**KIRKLEES METROPOLITAN COUNCIL
INVESTMENT & REGENERATION SERVICE**

Reference No:	2024/62/90099/W
Site Address:	Mellbreak, 161, Causeway Side, Linthwaite, Huddersfield, HD7 5SJ
Description:	Erection of dormer windows and orangery to rear (within a Conservation Area)
Recommending Officer:	Laura Yeadon

DECISION – REFUSED

Officer Report

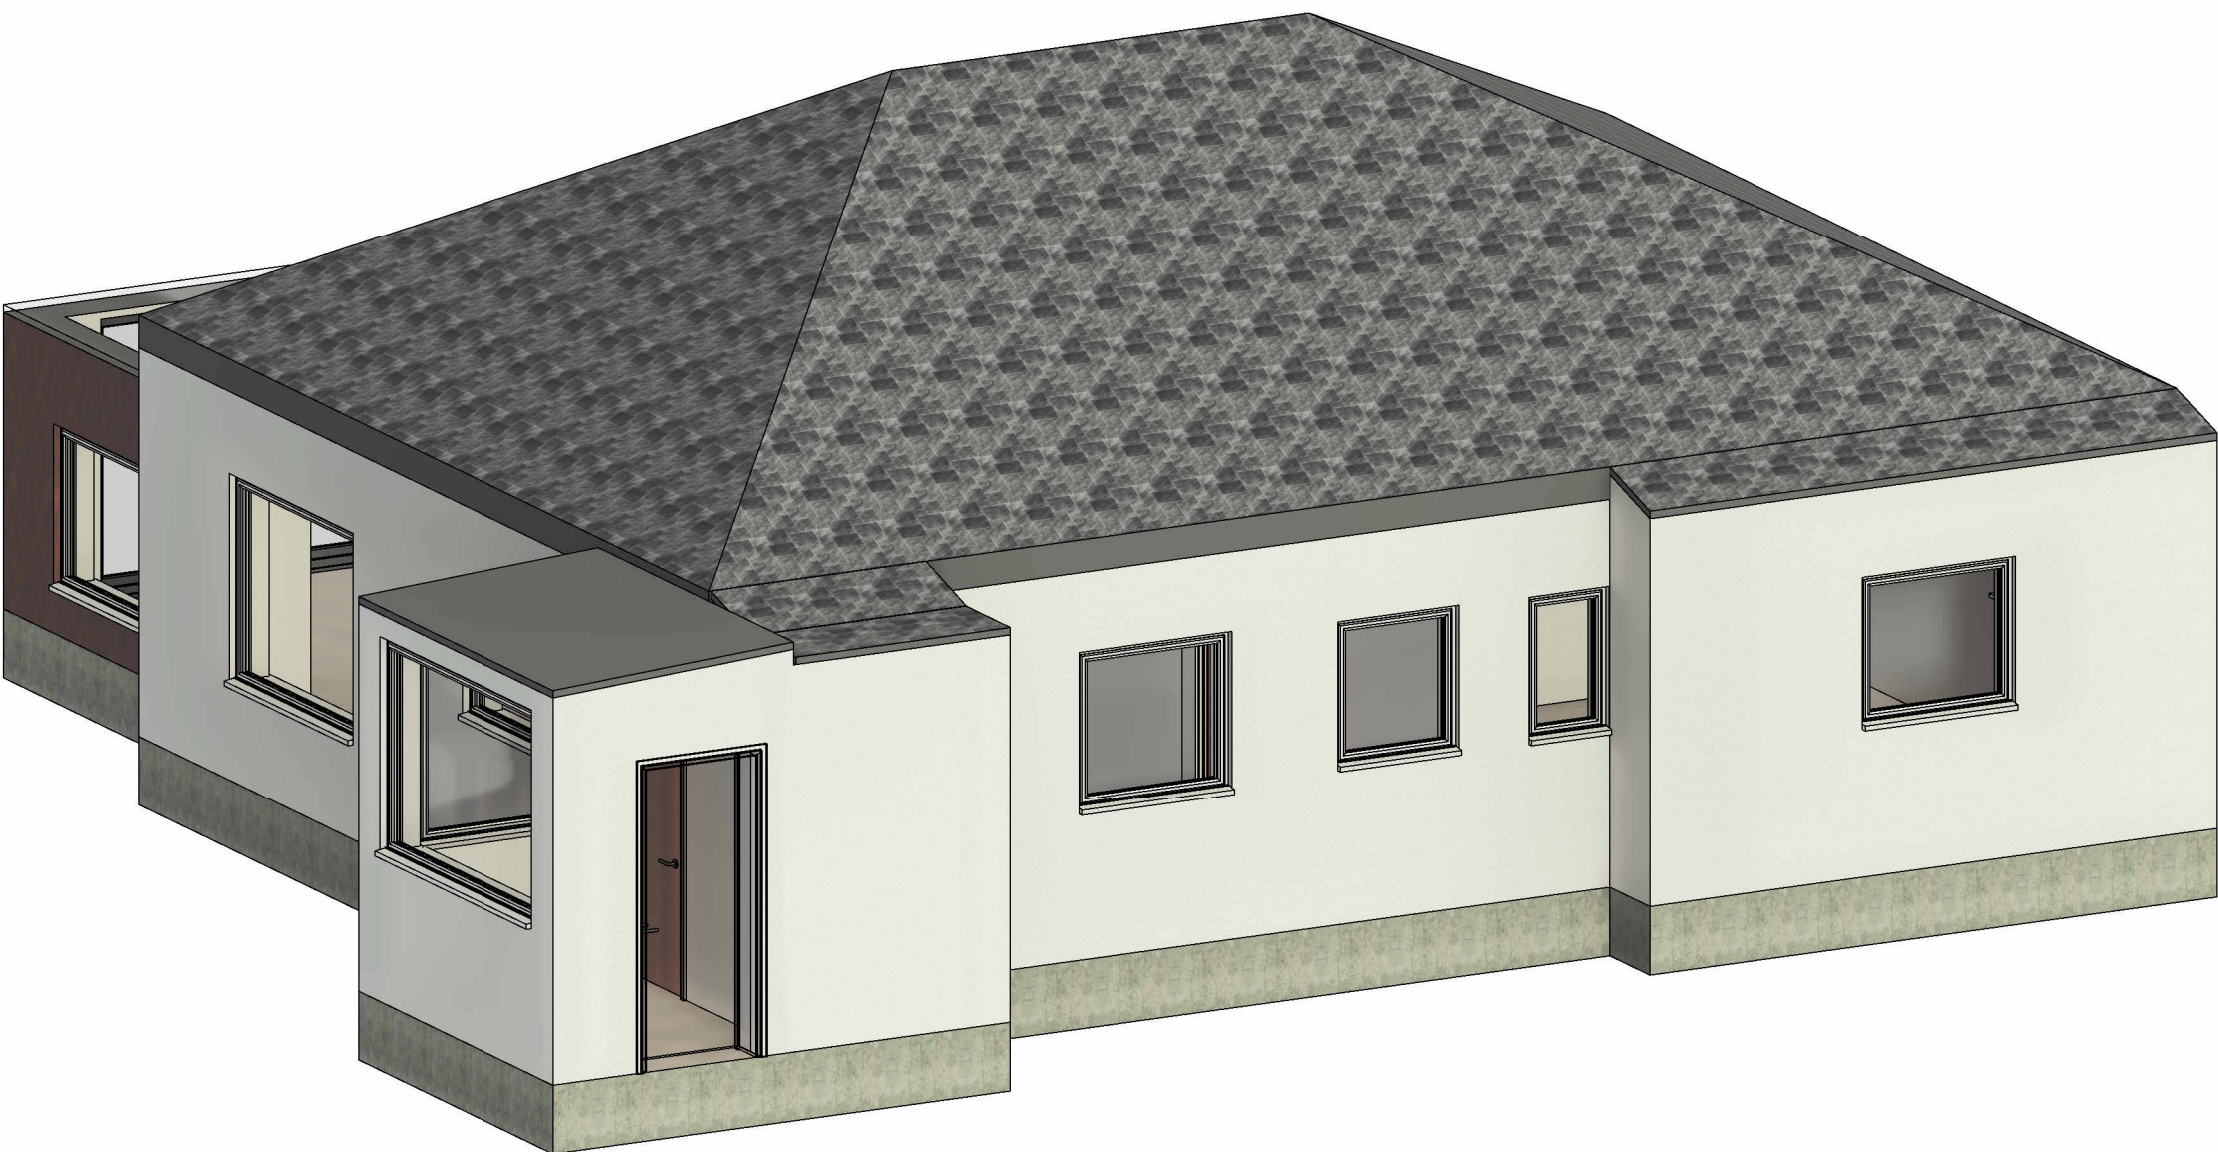
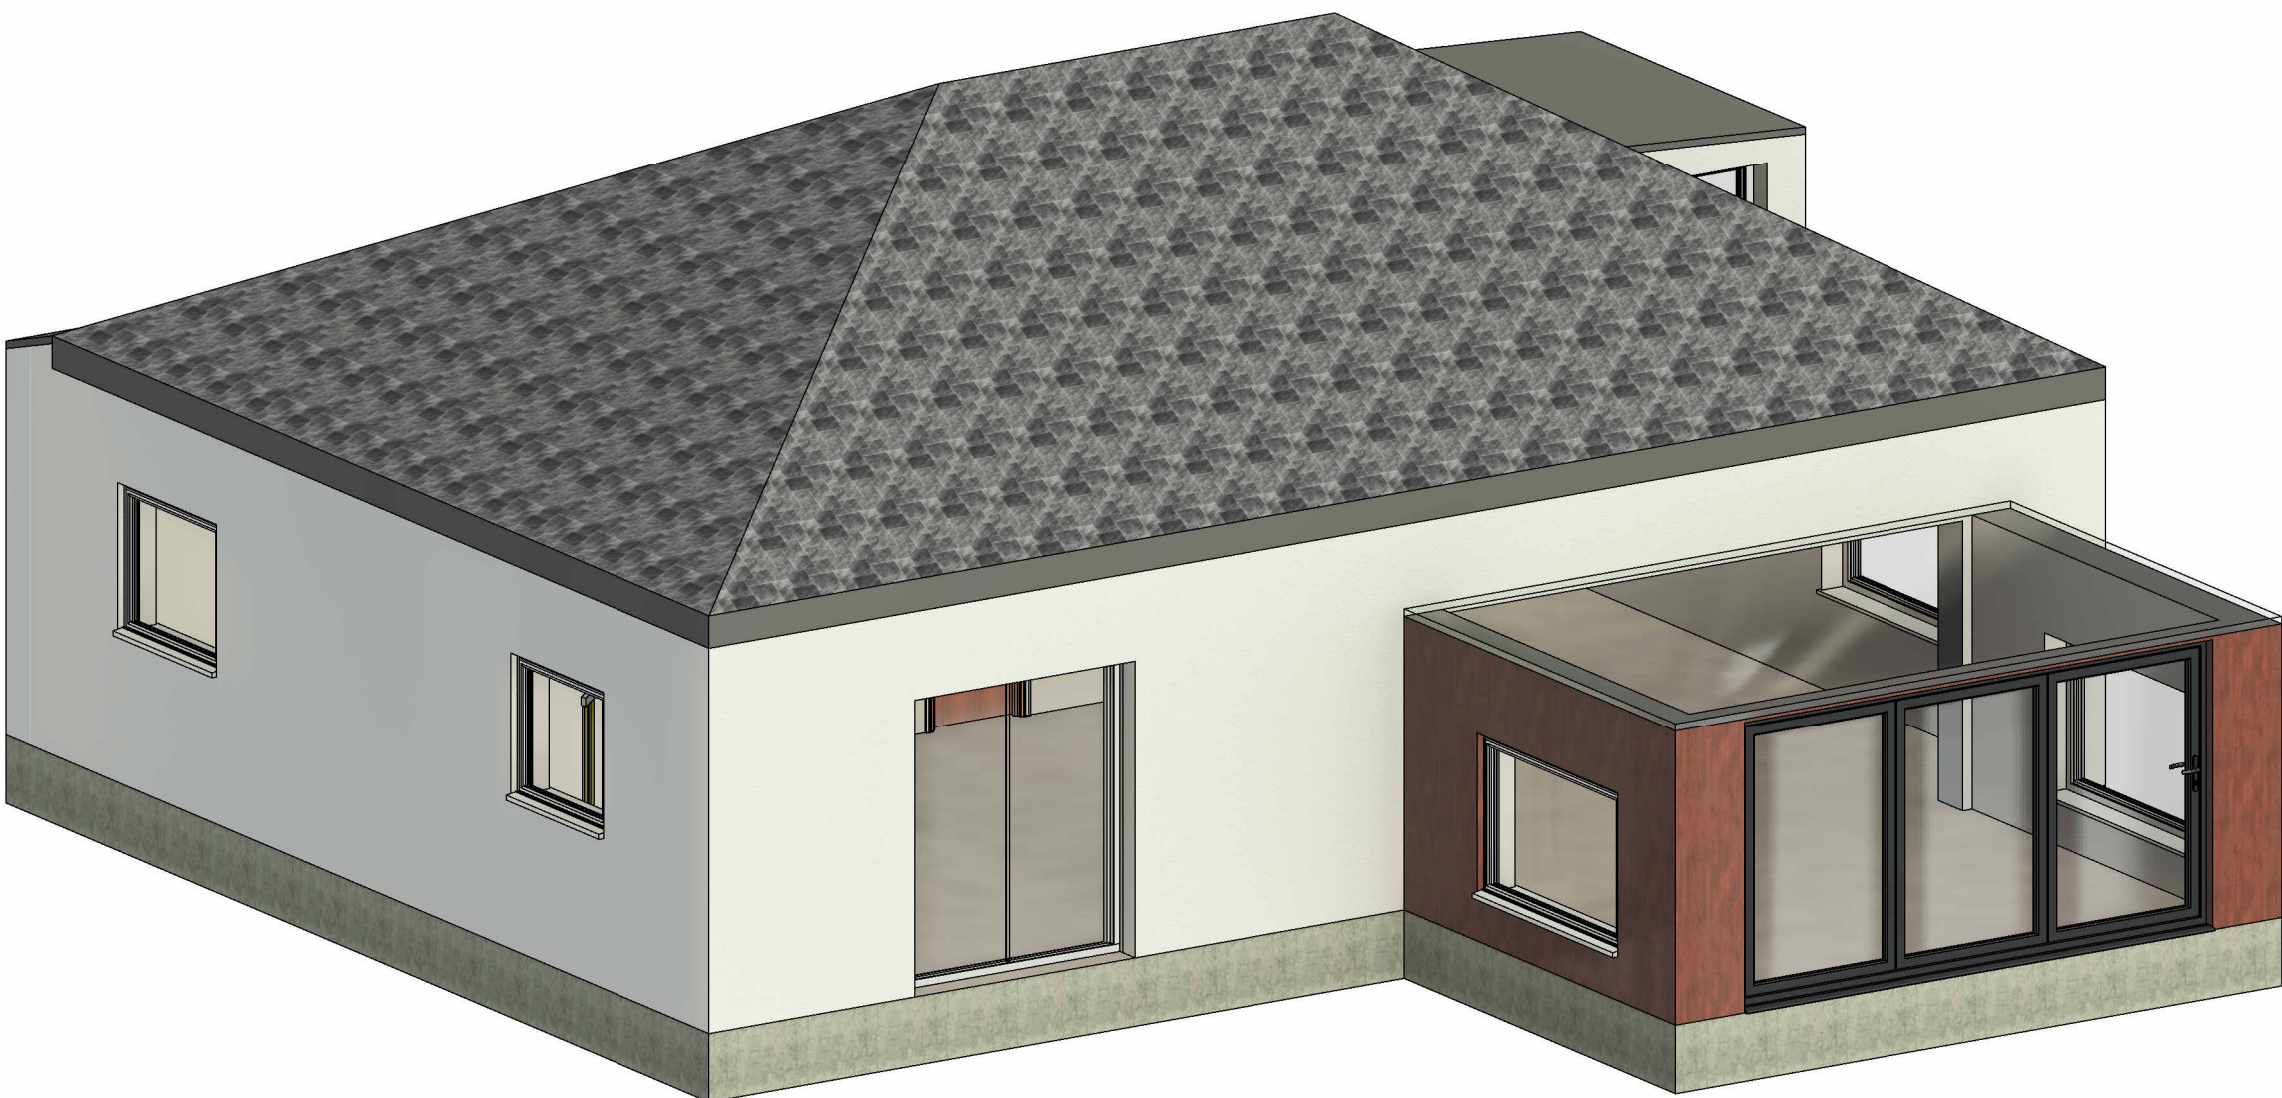
The dormer extension is located on the rear elevation of the property and built up from the eaves forming a flat roof structure which lies flush with the existing roof ridge. Due to the design of the development, the dormer projects beyond the side elevation hipped roof slopes. The width of the dormer is the full width of the rear elevation of the property and finished in white render.

The orangery is located on the rear elevation of the property, set in from the side elevation by 0.7 metres. It projects from the rear elevation of the property by 3.3 metres being a width of 4.8 metres with an overall flat roof height of 2 metres. The orangery is constructed from timber. It is noted that the orangery requires a level of underbuild which is provided, in this case, by the unlawful terrace structure which does not, in its entirety, form part of this application.

The design of the proposed dormer is a very large and dominant structure which is more akin to a flat roof first floor extension to the bungalow. Due to the projection from the sides of the original roof slope, the resultant structure introduces a very large, overly prominent structure which, due to its size and finishing material is not a subservient design which is in keeping with the original design principles of the host property and is out of keeping with the wider character of the locality.

Proposed Site Plan
1 : 200

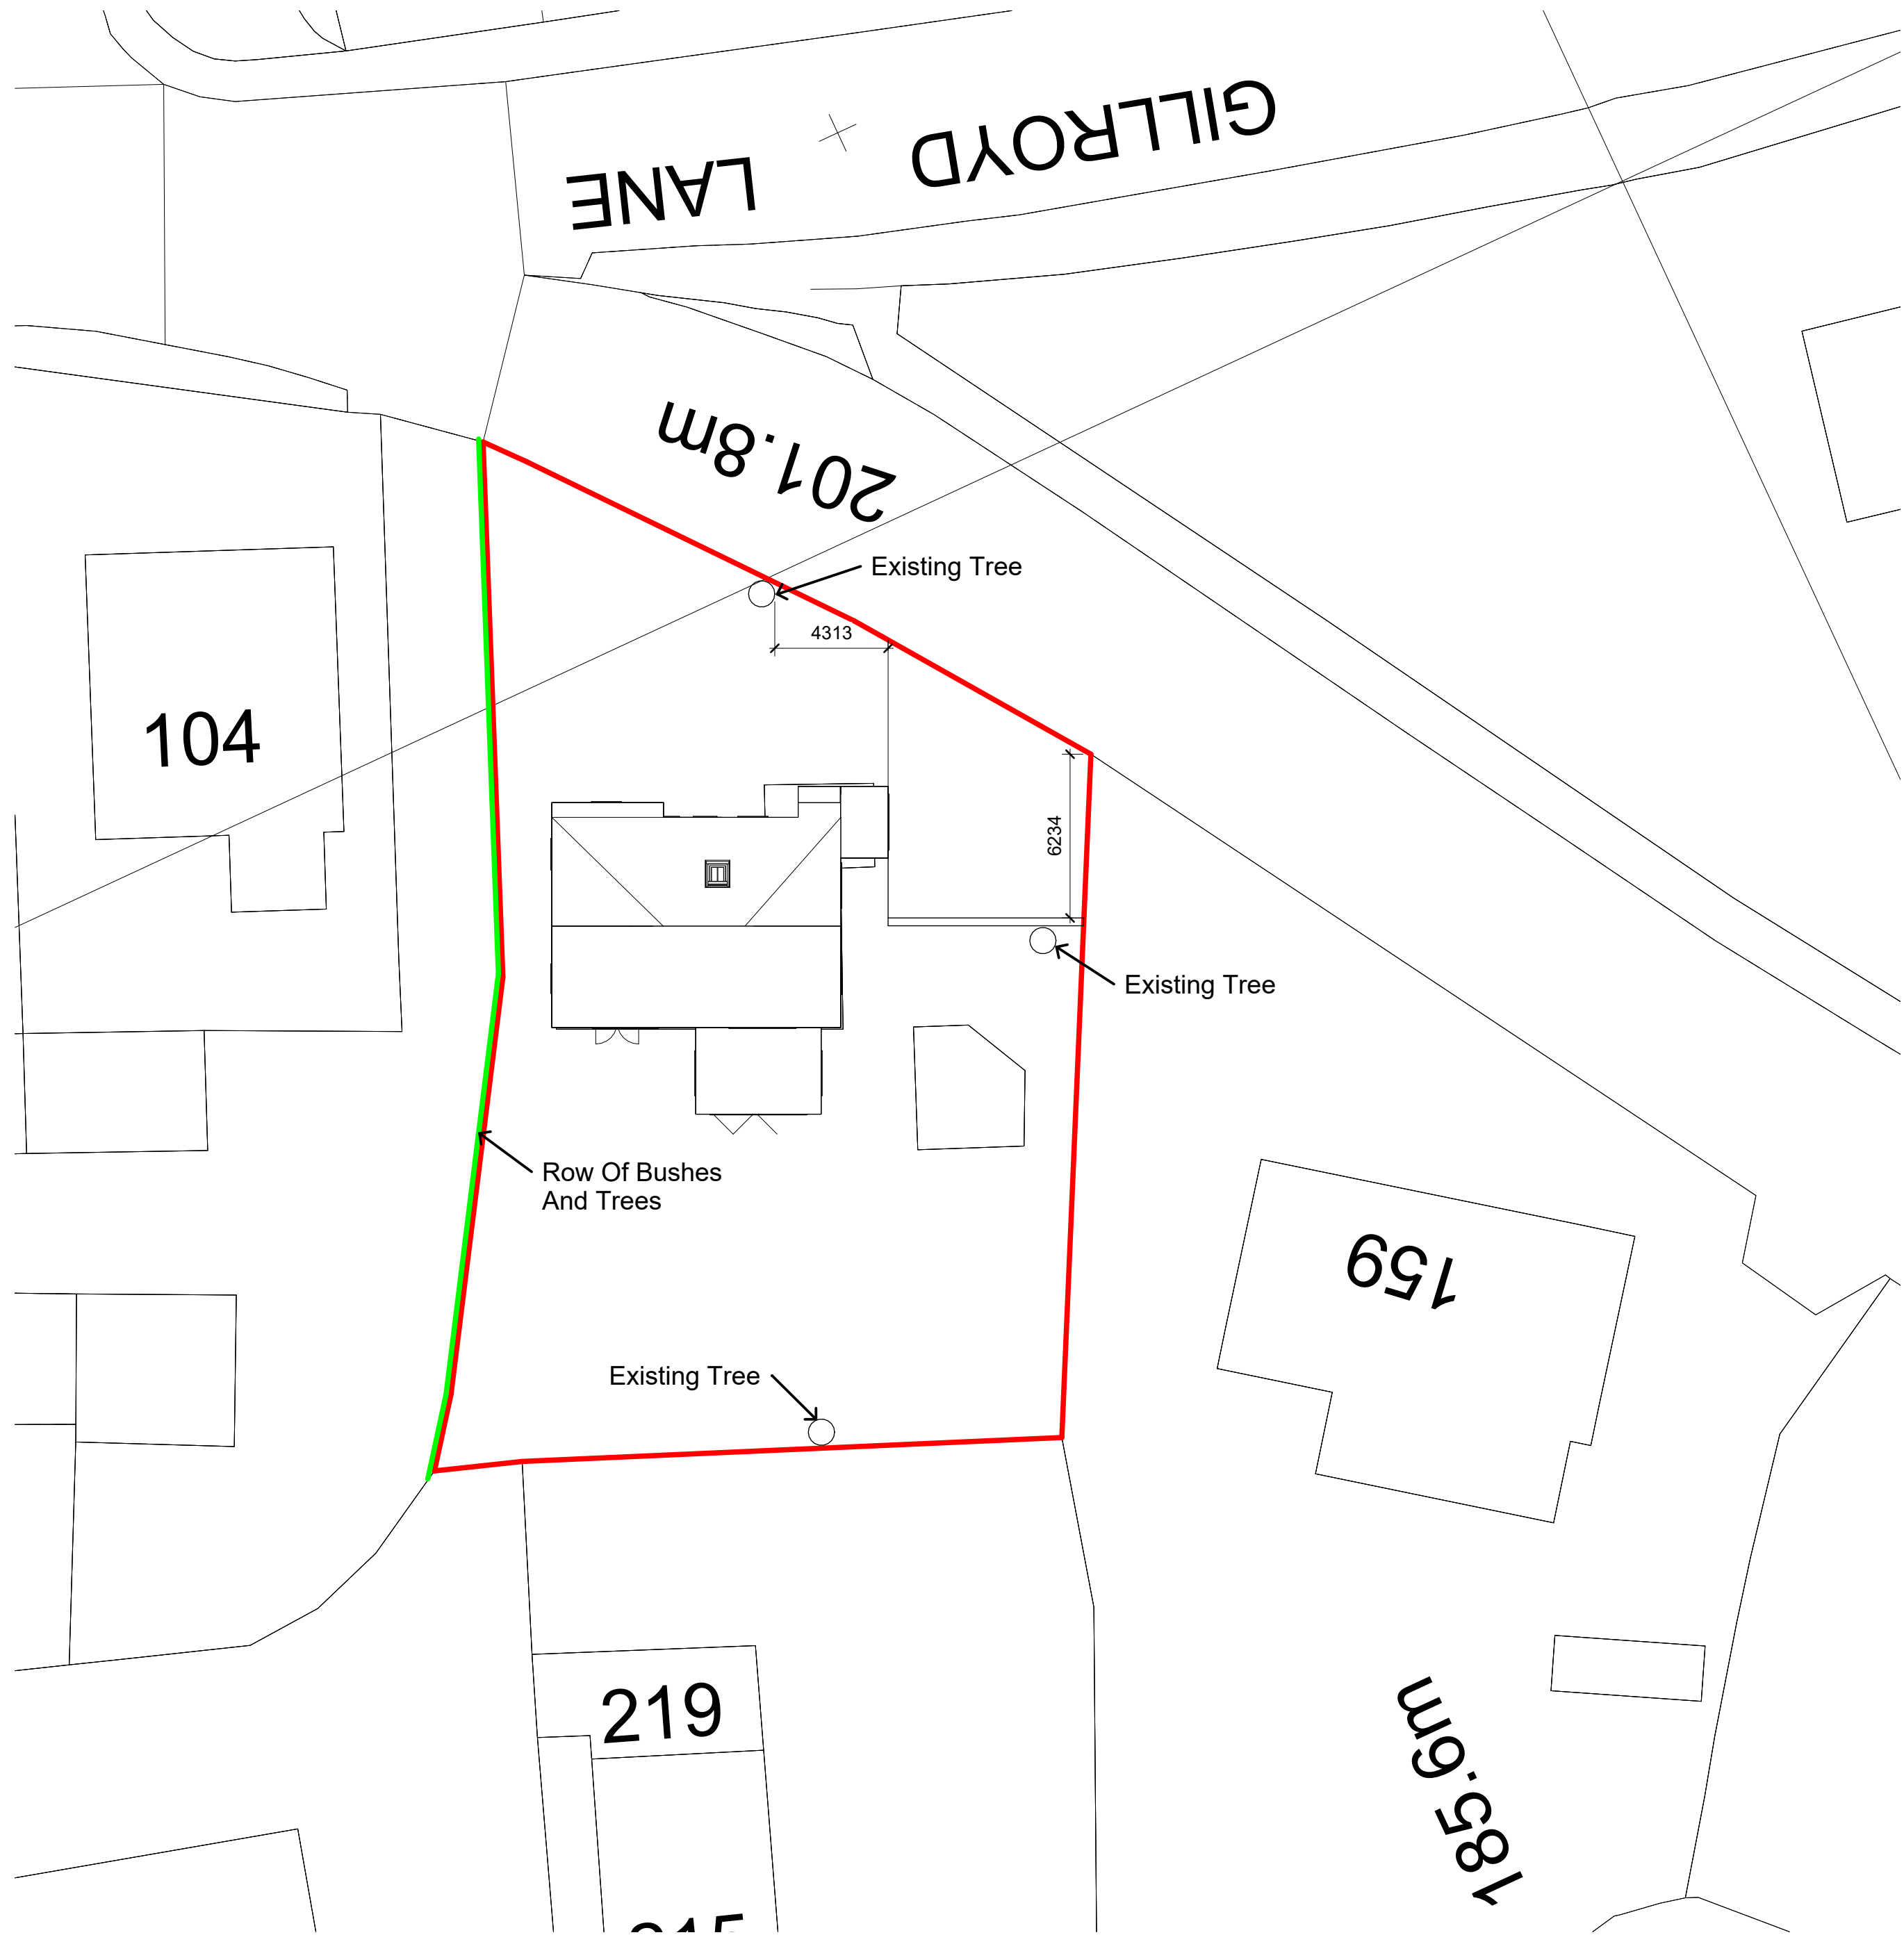
Officer Note: *It is important to note that there are elements of construction works that have taken place at the dwelling which require planning permission that are not shown on the submitted plans. These elements specifically are:*

- *Outbuilding which is not permitted development due to the property being within a Conservation Area and this outbuilding being to the side of the dwelling*
- *Raised terrace which exceeds 30cm in height and therefore requires planning permission.*

Whilst there are concerns regarding overlooking at close quarters to neighbouring properties, as a result of the terrace, as the terrace is not shown on plan or within the description of development, the assessment of this application is undertaken on the basis of the description of the development seeking consent for a dormer extension and orangery.
